# CITY OF ALBUQUERQUE

**Re: Sonic Drive-in – 6420 Central Ave. NW Albuquerque**  
**Request for Certificate of Occupancy**  
**Transportation Development Final Inspection**  
Engineer's/Architect's Stamp dated 06-02-17 (K11D047)  
Certification dated 11-09-2018

SITE PLAN, DESIGN DATA
AND NOTES

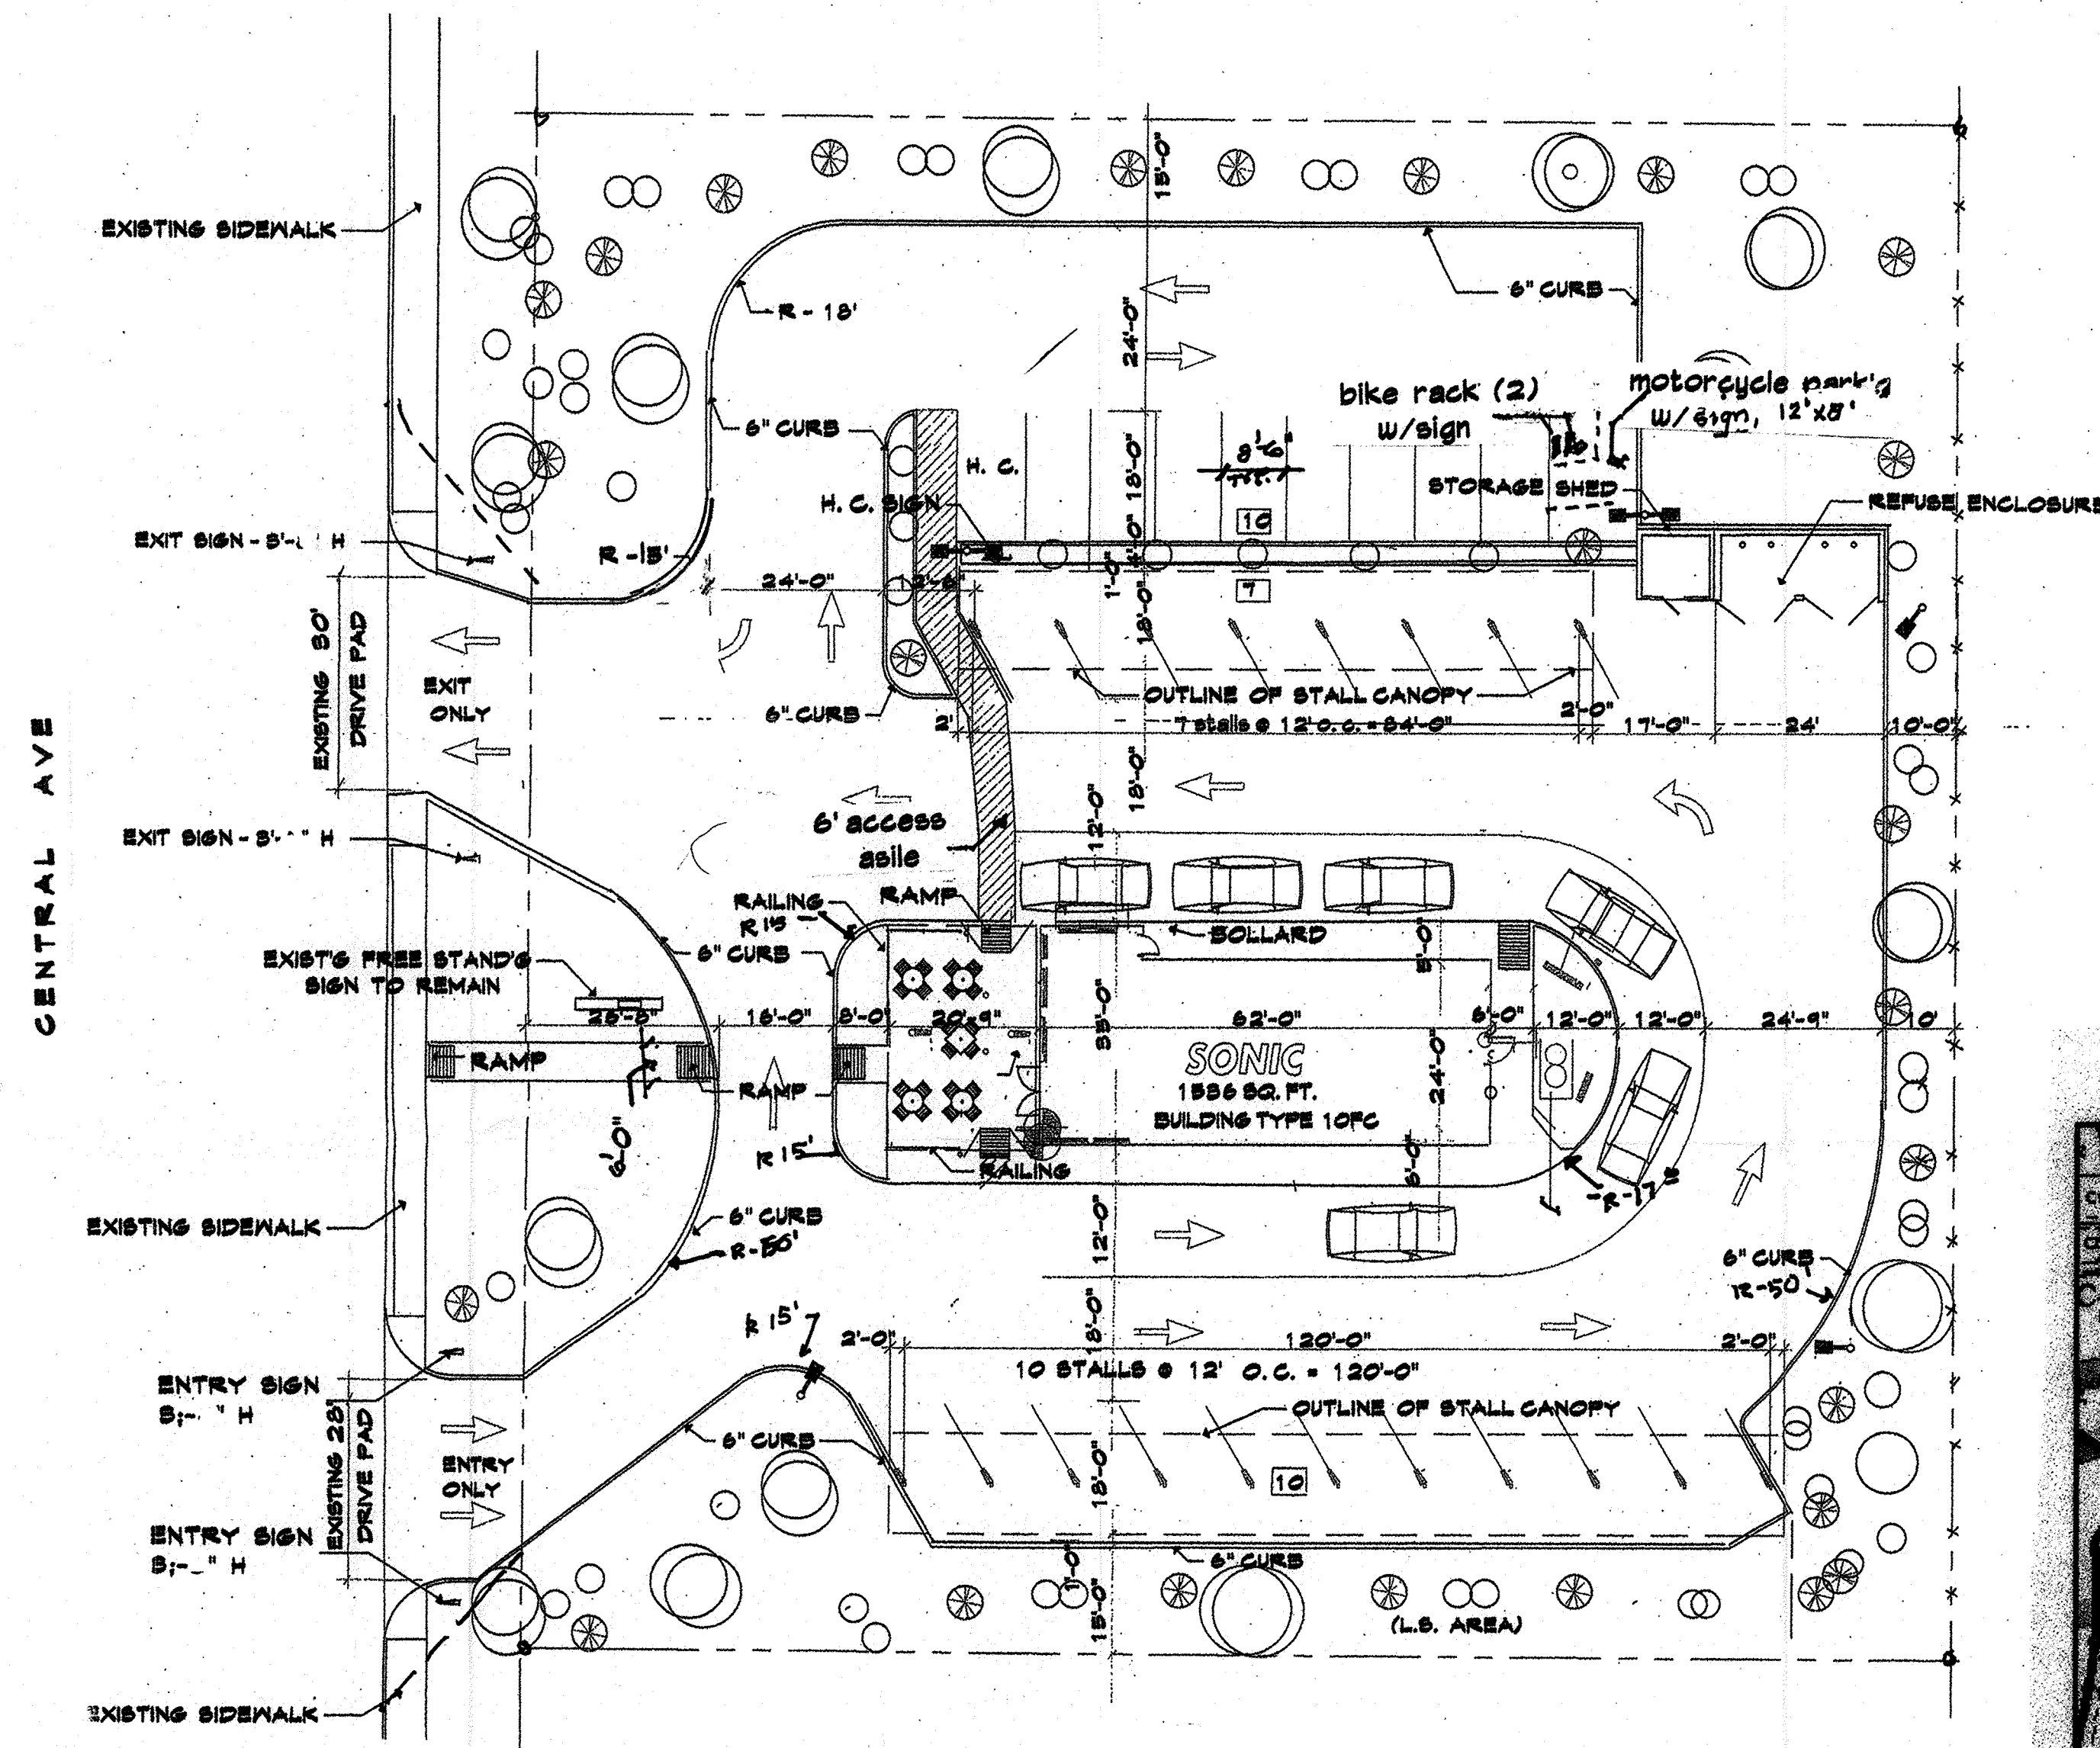
- The bike rack needs to be placed somewhere close to the entrance. Please move the bike rack.
